Appeal Decision

Appeal Ref: APP/R5510/D/24/3346942

11 Stuart Close, Uxbridge UB10 9NE

- The appeal is made under section 78 of the Town and Country Planning Act 1990 (as amended) against a refusal to grant planning permission.
- The appeal is made by Mr M Chopra against the decision of The Council of the London Borough of Hillingdon.
- The application Ref is 15309/APP/2024/326.
- The development proposed is front porch and rear ground floor extension.

01 PROPOSED ROOF PLAN

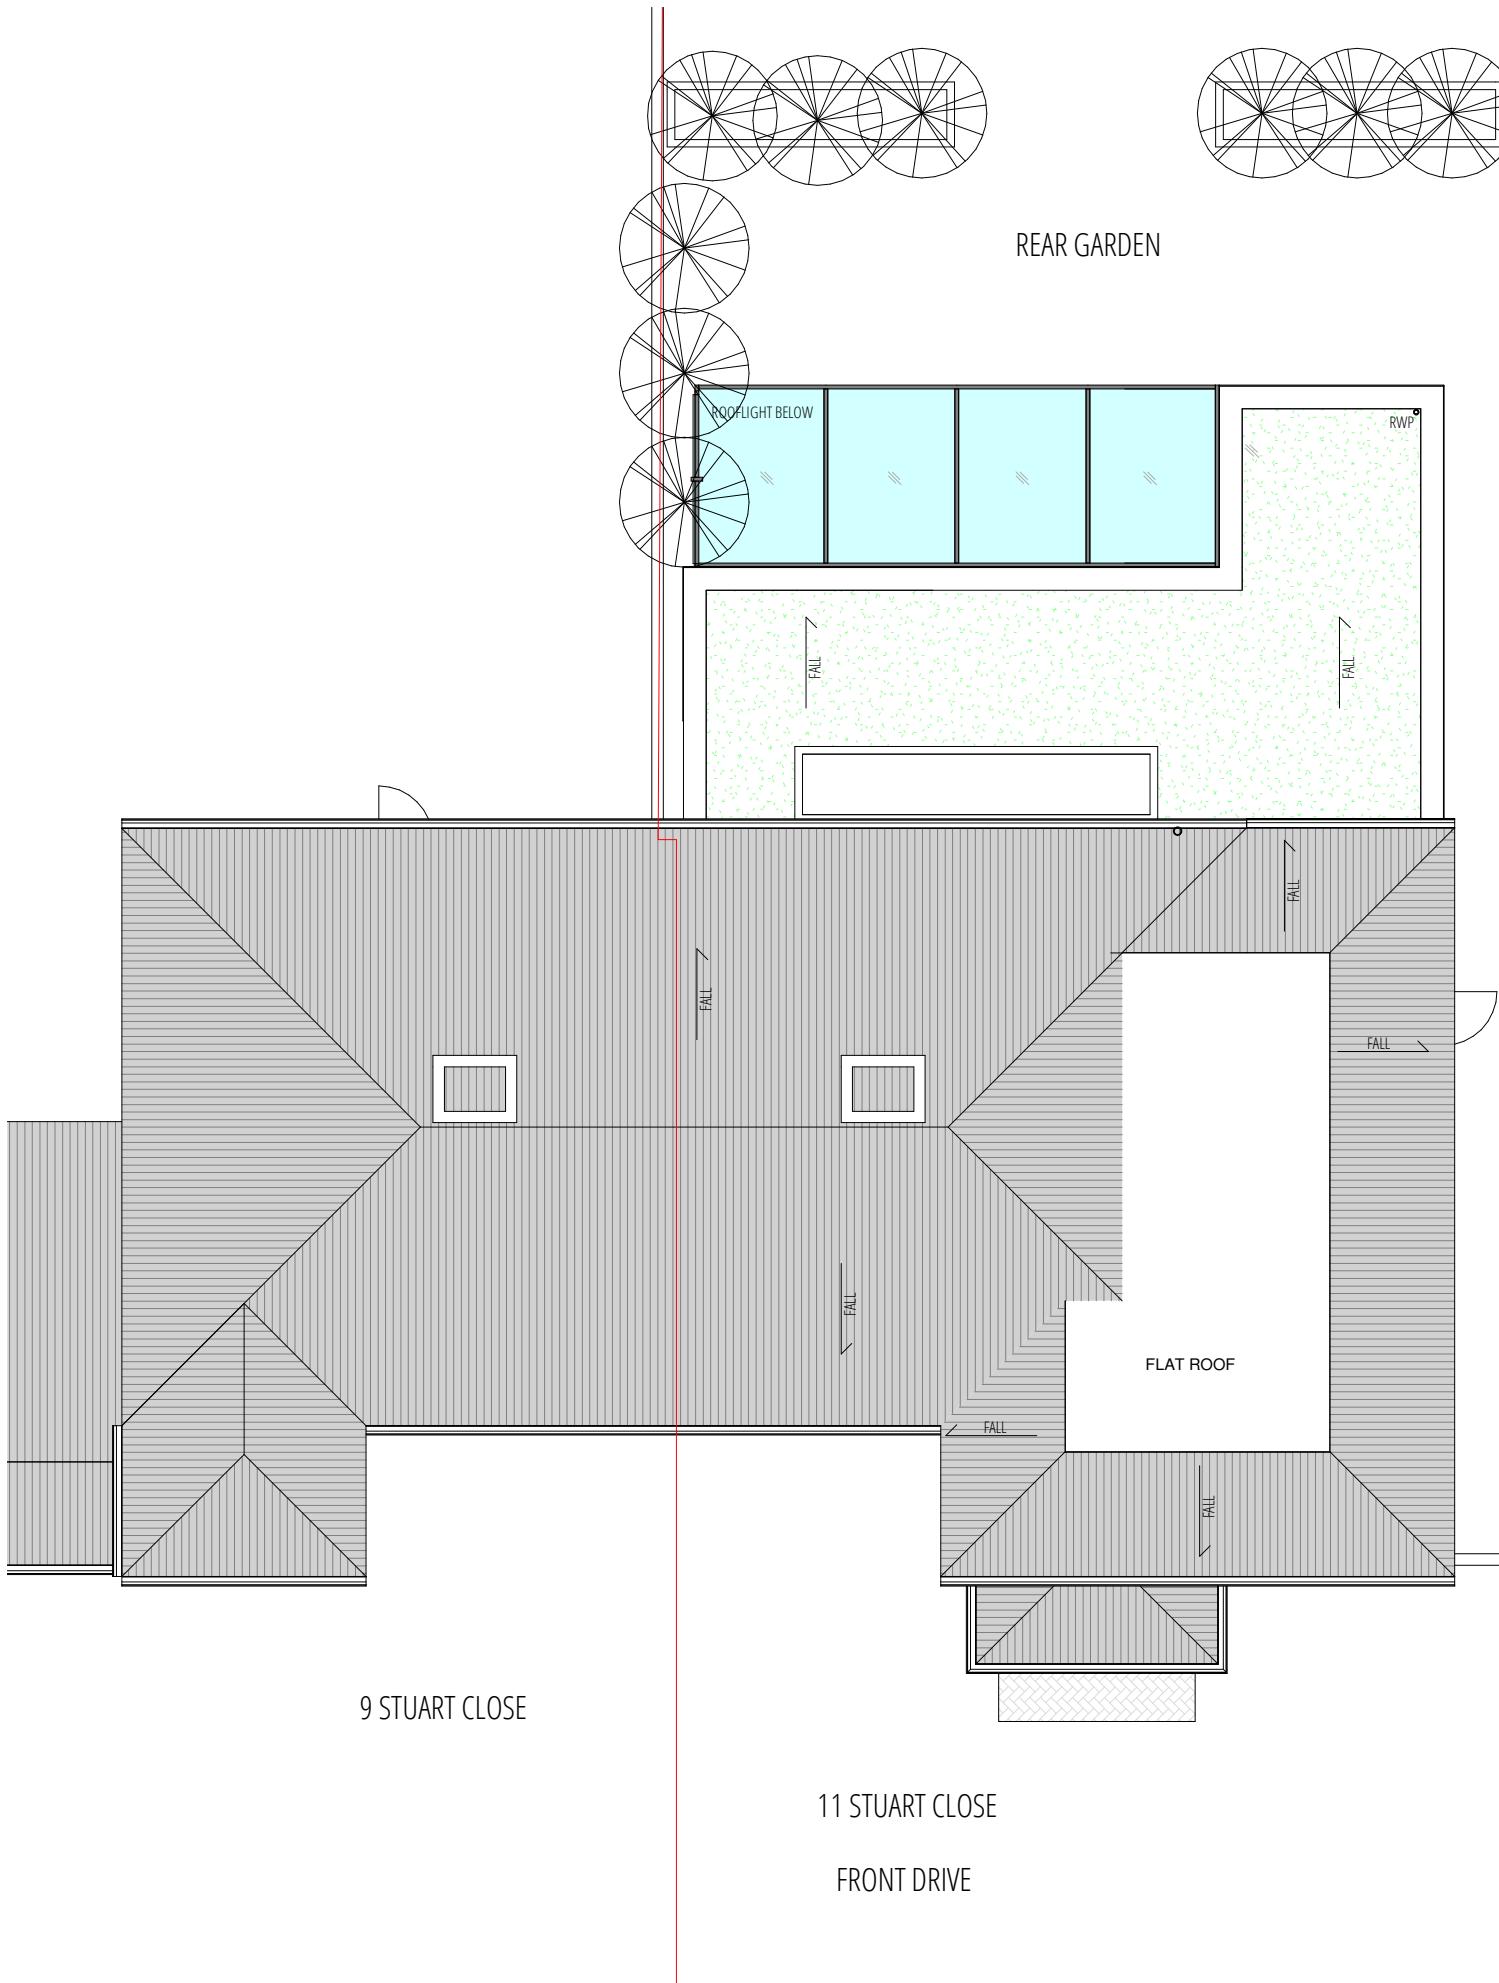
5. The depth of the proposed extension would considerably exceed the depth permitted by the Council's Policy DMHD 1. It would clearly breach a 45-degree line taken from the nearest neighbouring window to the boundary. I have taken into account the height of the boundary fence and the impact of the appellant's existing, lower, conservatory. However, in my judgement, the depth of the proposed extension adjacent to the common boundary would lead to an unacceptable mass of development. The proposed extension would harm the living conditions of the occupiers of No 9 by reason of being overly dominant and visually intrusive.

Rev	Date	Note
P1	06-02-24	Planning issue
PROJECT		
11 Stuart Close Uxbridge UB10 9NE		
DRAWING TITLE		
PROPOSED ELEVATION 2 OF 2		
PROPOSED DEVELOPMENT / STATUS		
GF REAR & FRONT PORCH EXTENSION		
DRAWN BY	Author	CHECKED BY

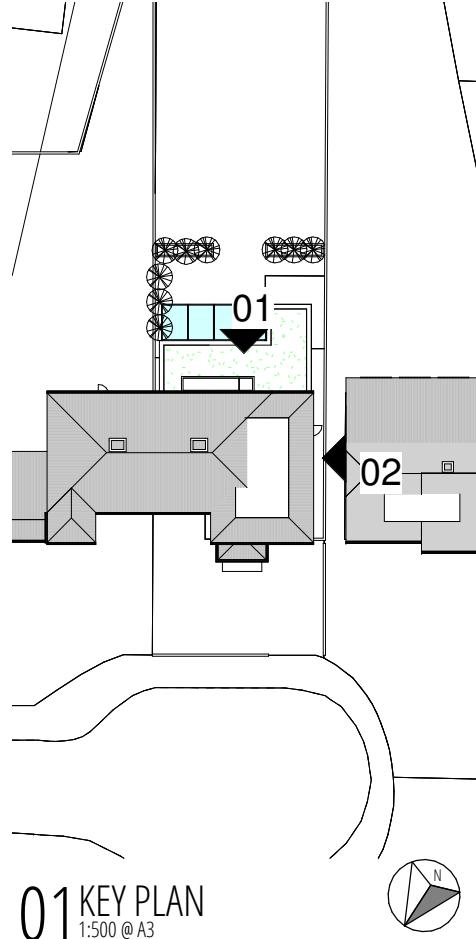
6. The glazed element of the extension adjacent to the boundary would be translucent and lighter in form than a solid material. However, if permitted, this area could well be infilled in the future. Additionally, if blinds or curtains were to be fitted, they would, in effect, present a more solid appearance than glazing alone. It would be unreasonable to require open glazing to be retained by condition.

8. Turning to design matters, the glazed element of the proposed extension would to some extent break up the appearance of its massing. However, the extension would remain a large and bulky development due to its excessive depth and size and it would dominate the existing property. Furthermore, its overall size would be uncharacteristic of other extensions in the surrounding area.

PROPOSED REAR VIEW

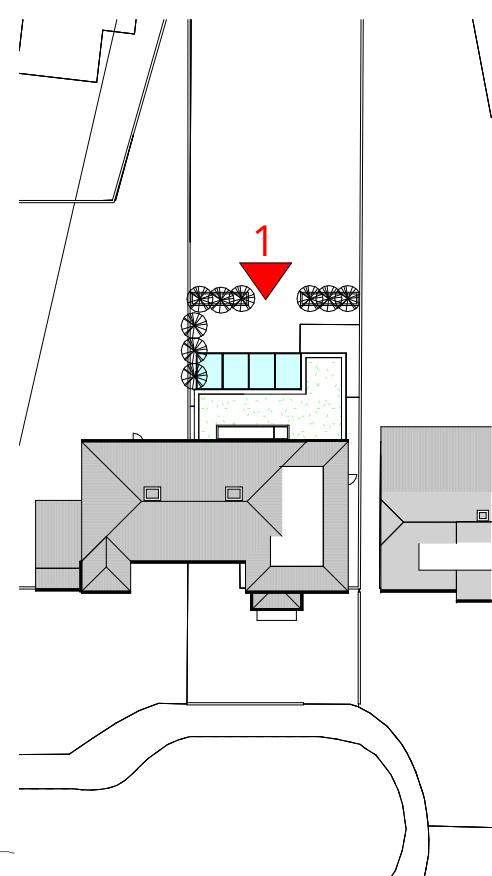
9. I conclude that the size, width, bulk and massing of the proposed rear extension would be a dominating and incongruous form of development that would fail to respect the form and composition of the host dwelling. It would also harm the character and appearance of the surrounding area. The proposal would therefore be contrary to the collective design objectives of Policy BE1 of the Hillingdon Local Plan: Part One - Strategic Policies (2012), Policies DMHD 1, DMHB 11 and DMHB 12 of the Hillingdon Local Plan Part Two - Development Management Policies (2020) and Policy D3 of the London Plan (2021).
